**ADC Planning Consultation
Response from the Conservation Officer**

Application Number	EG/55/14/PL, EG/56/14/PL, EG/57/14/A, EG/58/14/PL, EG/59/14/PL
Address	The Barnham Hotel 28 Barnham Road Barnham PO22 0ES
Description	Various – See below
Case Officer	Mr. S. Davis

REAR ELEVATION-C AS PROPOSED
SCALE 1:50

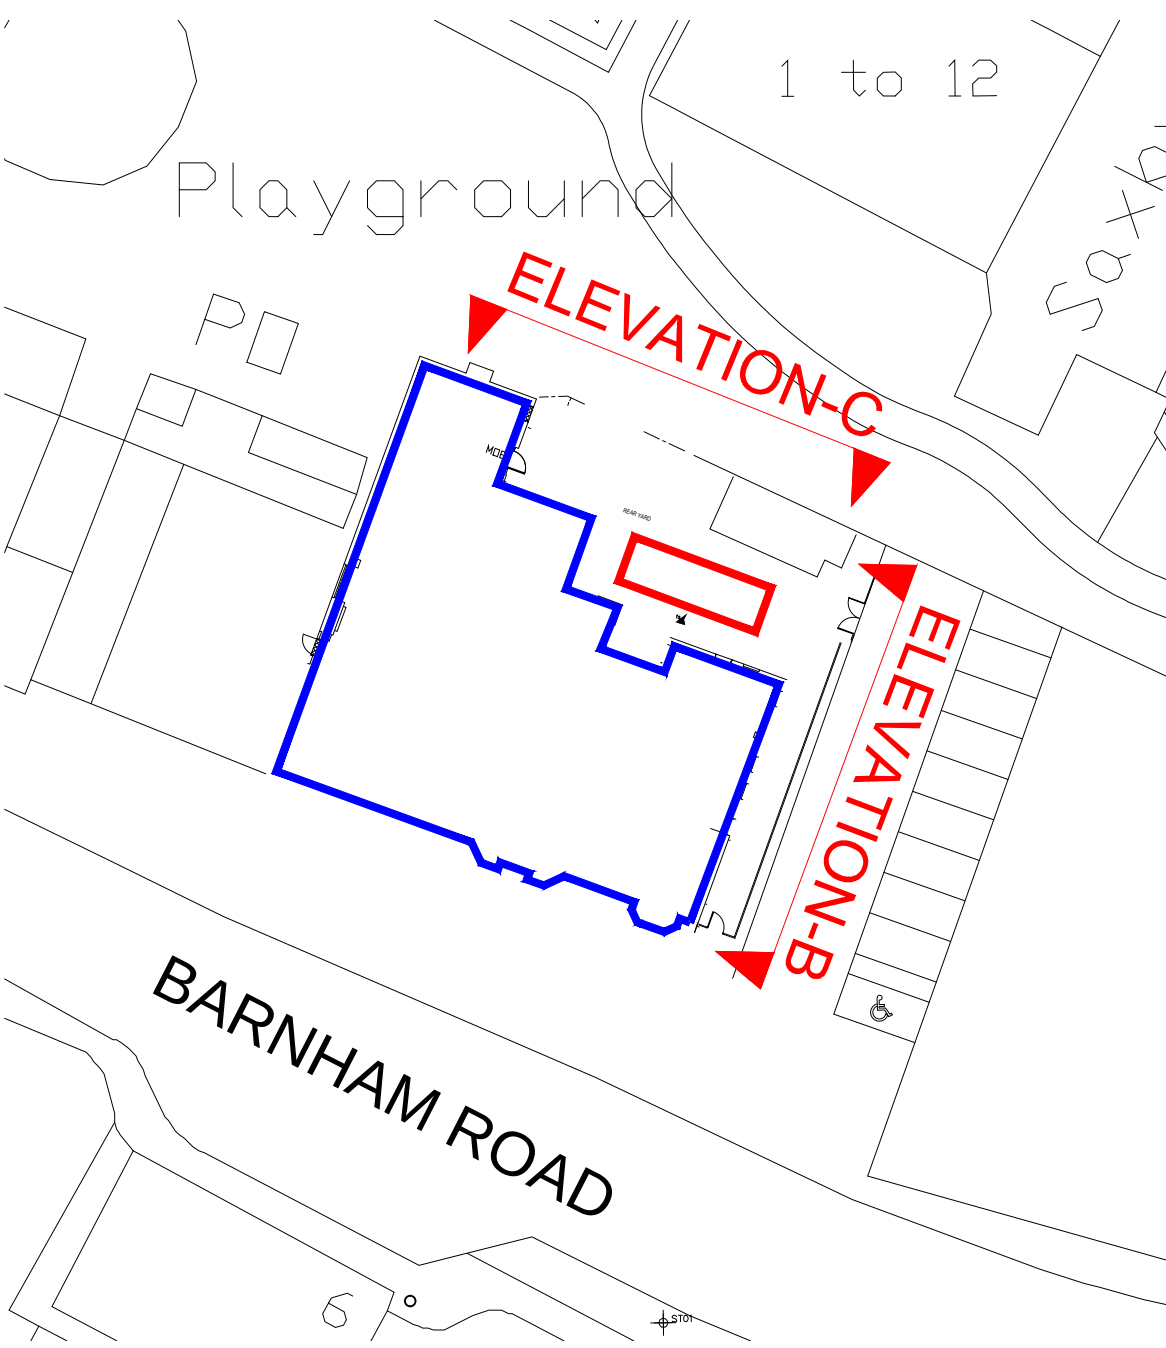
From the information available to me it appears as if the units will all be free standing structures in the rear amenity space. Consequently, it is considered that they will not have a negative impact upon the building
